**WEST SUSSEX COUNTY COUNCIL
LOCAL DEVELOPMENT SERVICES CONSULTATION**

APPLICATION No.: lu/195/09/I

PROPOSAL: Internal works

SITE: Flat 4, 16 South Terrace. Littlehampton

BST 164/3

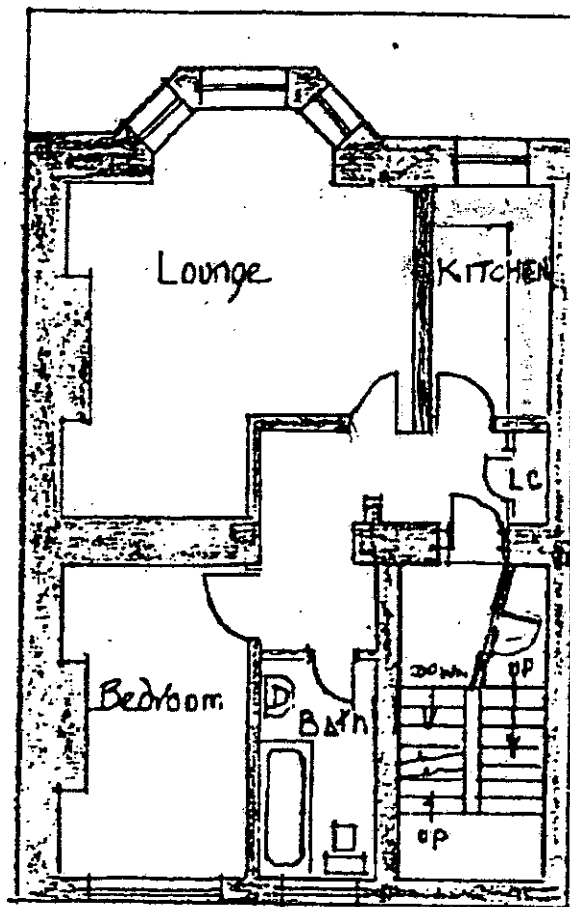
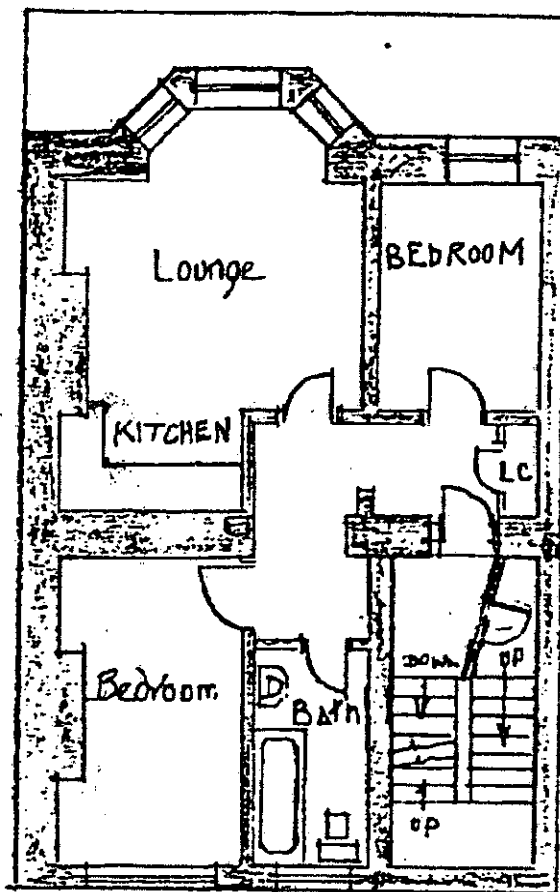
The revision to the internal wall is minor. It is not detrimental to the historic fabric of the building. Permit.
